From: Adrian Hoy [REDACTED]
Sent: 23 July 2019 08:14
To: Simon Davis <Simon.Davis@arun.gov.uk>
Subject: RE: West Street Bognor Regis RE: BR/73/19/PL

We have accepted a revised FRA on this application which outlines measures (extra ground raising) to take the site out of the future Flood Zone 3a (our SFRA indicates that the site will be in 3a by 2061). Can you just advise whether this alters your previous comments which were to impose conditions PCENG2 and the informative INFORMD. I need your response before the 14th August 2019.

FLOOD RISK ASSESSMENT AND MITIGATION

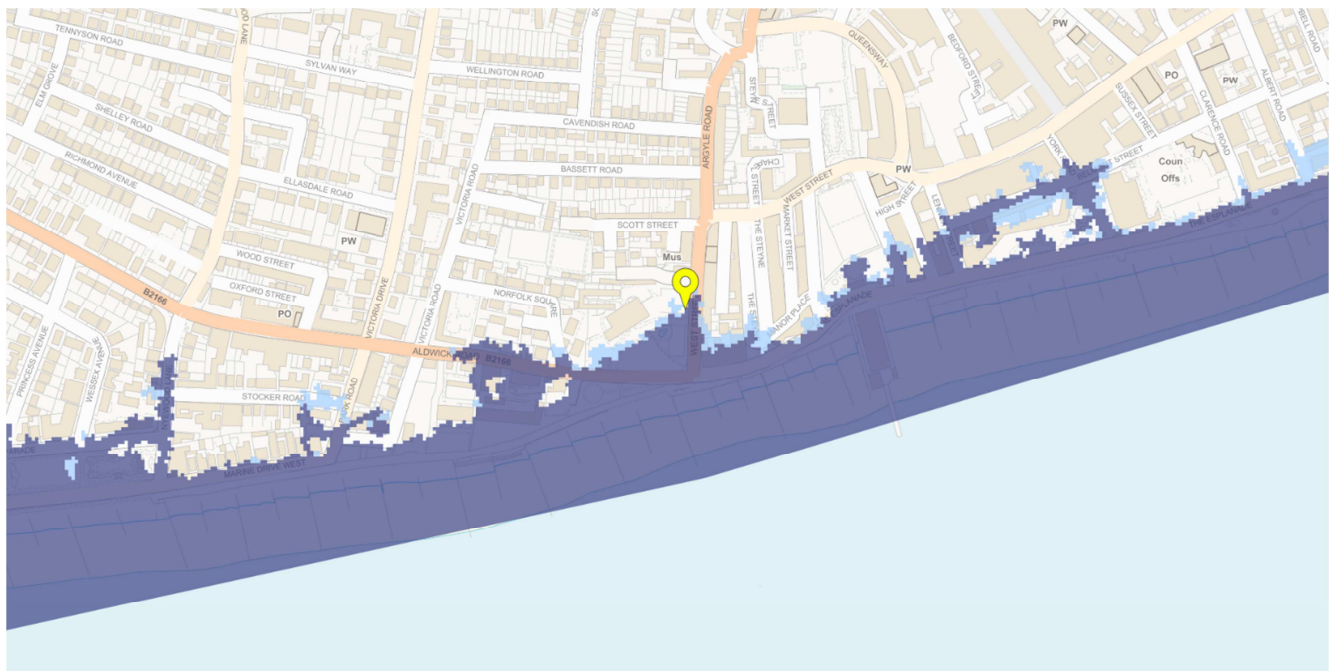
The methodology for determining the predicted flood level for 2061 is not correct. Flood levels should be requested from the EA.

Interpreting SFRA mapping against topo levels has a rather significant margin for error. The SFRA is quite dated now in flood risk terms, and is based on very coarse LiDAR data to create a digital terrain model to determine flood extents. For example, what the model thinks is 5mAOD could easily be 5.3m AOD in reality, or 4.7mAOD. As a result, extents could be incorrect. I'd always advocate working with predicted levels rather than extents. Therefore, I would be very hesitant about stating the ground raising moves it outside of future FZ3a. The EA are the ones who would confirm this though.

Dear Simon
Thanks for your assistance with FRA – it remains as I have sent to you.
Kind regards
Adrian
